Botley West Solar Farm

Change Request 2: Change Report

September 2025

PINS Ref: EN010147

Relocation of the Proposed Substation and Western Panel Removal

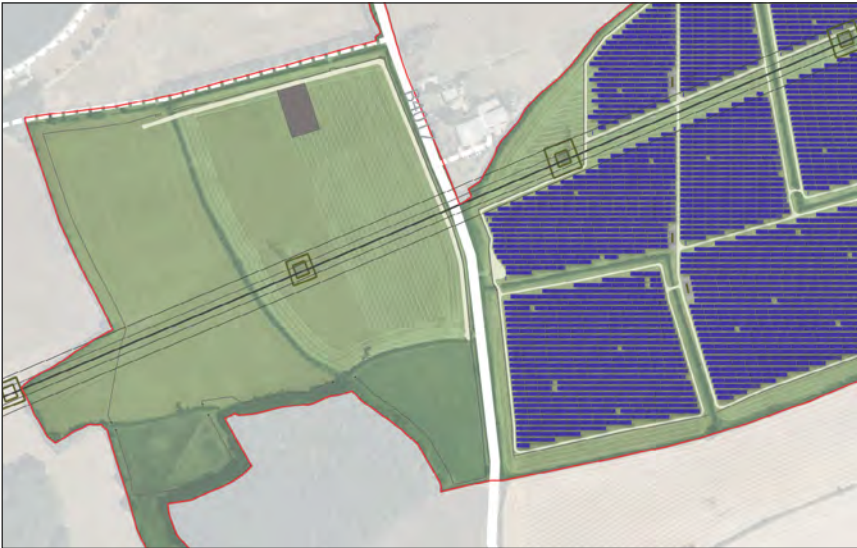
Refinement of Project layout and design to reposition the main Project substation and secondary substation as shown on Sheet 13b of the Works Plans [AS-005] (see Appendix A attached to this report)

- 2.6.3 Sheet 13b of the Works Plans identifies the layout of the Main Project substation and additional solar array, if the new National Grid substation is to be delivered by National Grid on adjacent land to the west beyond the Order Limits. As stated above, the original assessment assumed solar arrays directly in place of the land reserved for the new National Grid substation and the Project main substation remaining to the east of that land parcel. The Applicant now proposes a repositioning of the solar array installation area in the Southern Site.

- 2.6.4 Proposed Change 3 would alter the layout of the solar installation but would not change the overall area of solar installation proposed. This change would allow for a shorter, more efficient and more cost-effective cable connection to the National Grid substation. This was recognised by the ExA in the Issue Specific Hearing 1 (on DCO and Strategic Matters) and the Applicant is seeking this change partly in response to that suggestion.

- 2.6.5 The Main and secondary substation has also been sited to allow for a large landscape planting corridor to be accommodated along the northern edge of the facility as well as to avoid the existing hedgerow to the east and the proposed Greenway to the west. The landscape buffer on the northern boundary area will be planted with hedgerow and trees to allow for improved screening of the facility. The overall size of the facility will not change but there is a slight stagger in the footprint (for the secondary substation) to accommodate the landscape buffer to the north. The final slab level will be determined following detailed design but the plans assume a cut and fill balance i.e. no materials or so significant quantities of material taken off site during construction.
